# PORTLAND MAINE

April 14, 2010

Re: 3 Van Vechten Street – 410 C036 - R-3 – disability variance – Permit #10-0358

# Plot Plan

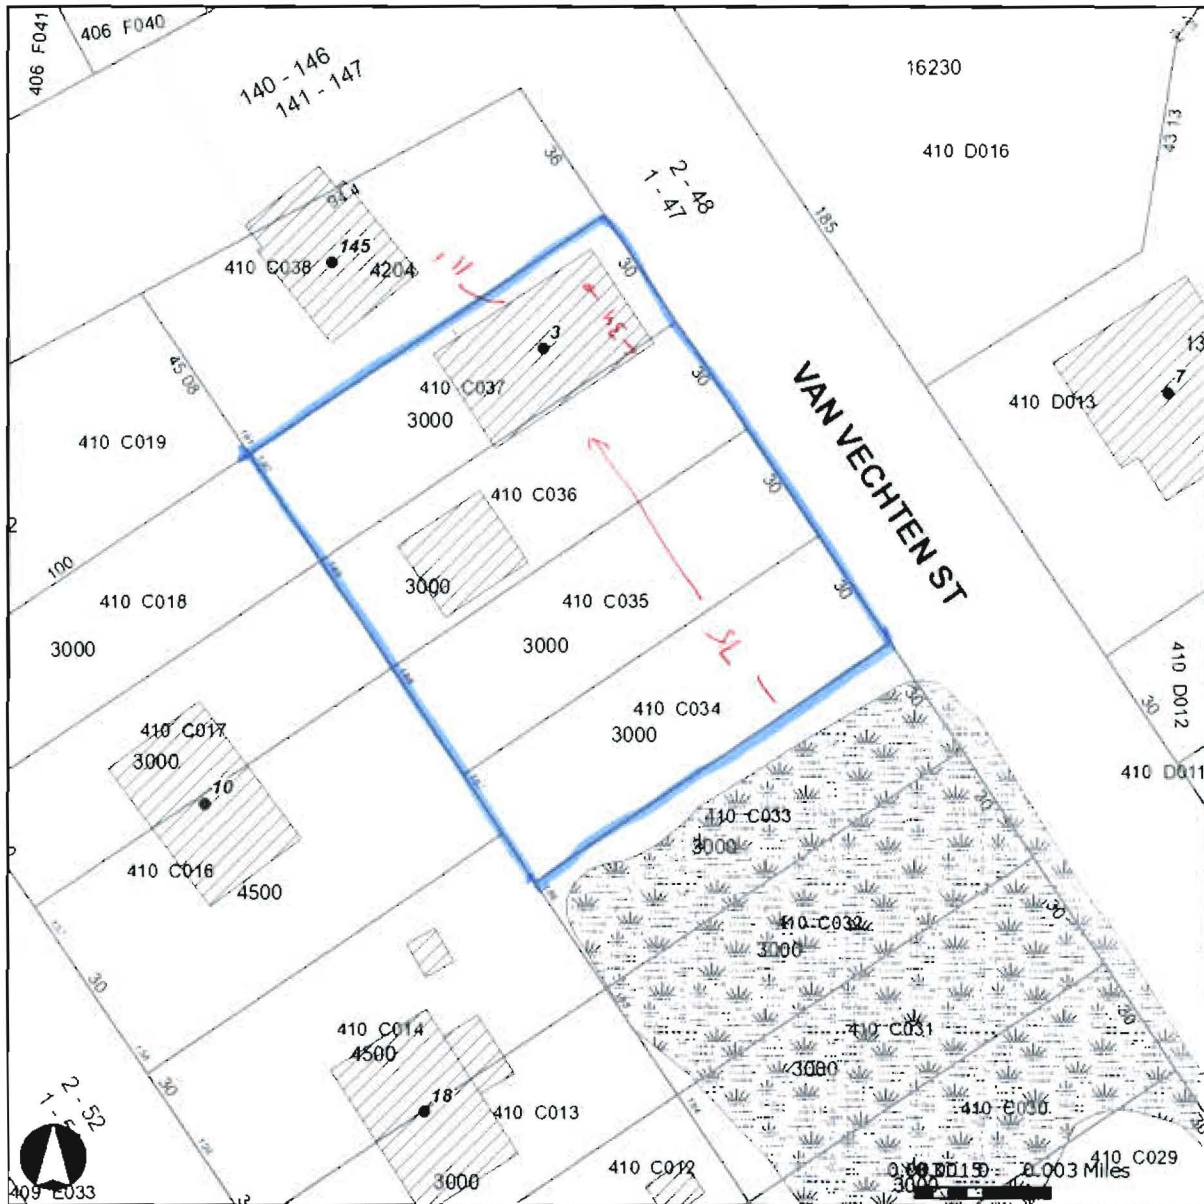
You applied for a permit to build a ramp and a five (5) foot by five (5) foot entry deck to make your house at 3 Van Vechten Street accessible for a wheel chair. 3 Van Vechten Street is located in the R-3 residential zone. The required front yard setback is twenty-five (25) feet [section 14-90(d)(1)]. The plot plan you submitted showed the setback to the proposed ramp as three (3) feet. The required side setback is eight (8) feet [section 14-90(d)(3)]. Your permit application had conflicting numbers for the side setback to the proposed ramp and entry deck. The plot plan said it was nine (9) feet but the information sheet said the setback to the existing house was eleven (11) feet which would make the entry deck six (6) feet from the side property line. Since the ramp has to be installed immediately, the permit has been issued to build it, but you need to apply for a disability variance within thirty days of the permit being issued, since the ramp and entry deck do not meet the required front setback and may not meet the required side yard setback.
